2023/0880

Development of 1 no. Self-Build Residential Dwelling and associated works

Land to rear of Greenland Cottage, High Hoyland Lane, High Hoyland, Barnsley

proposed section A - A

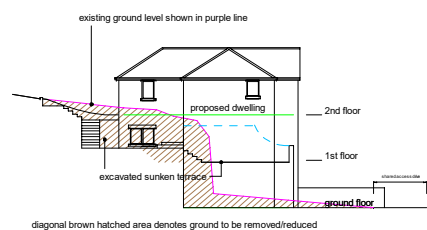
The proposed three storey dwelling lacks design detailing to reduce the impact of the height and mass of the building. It includes window details which add to the vertical emphasis of the dwelling and therefore emphasise the height of the building. Since the proposal will be viewed in the context of one and two storey houses in the vicinity, the height, massing and vertical emphasis will feel incongruent in the street scene. The design of the dwelling also includes an integral double garage with a door on the front elevation. The garage is over dominant of the front elevation, contrary to the guidance in the SPD Design of Housing Development. The use of regular coursed natural stone and natural roof slates would be a positive feature but do not overcome the concerns about the design which it is concluded result in a dwelling which has an unacceptable appearance in the street scene, contrary to local plan policy D1 and the SPD Design of Housing Development.

The proposed building will not be highly visible in the landscape but will be visible from views looking up to the site from the farmland to the south-east. It is concluded that the proposal would have a neutral impact on landscape character and as such does not comply with local plan policy LC1 as it would not enhance the character and distinctiveness of the area.
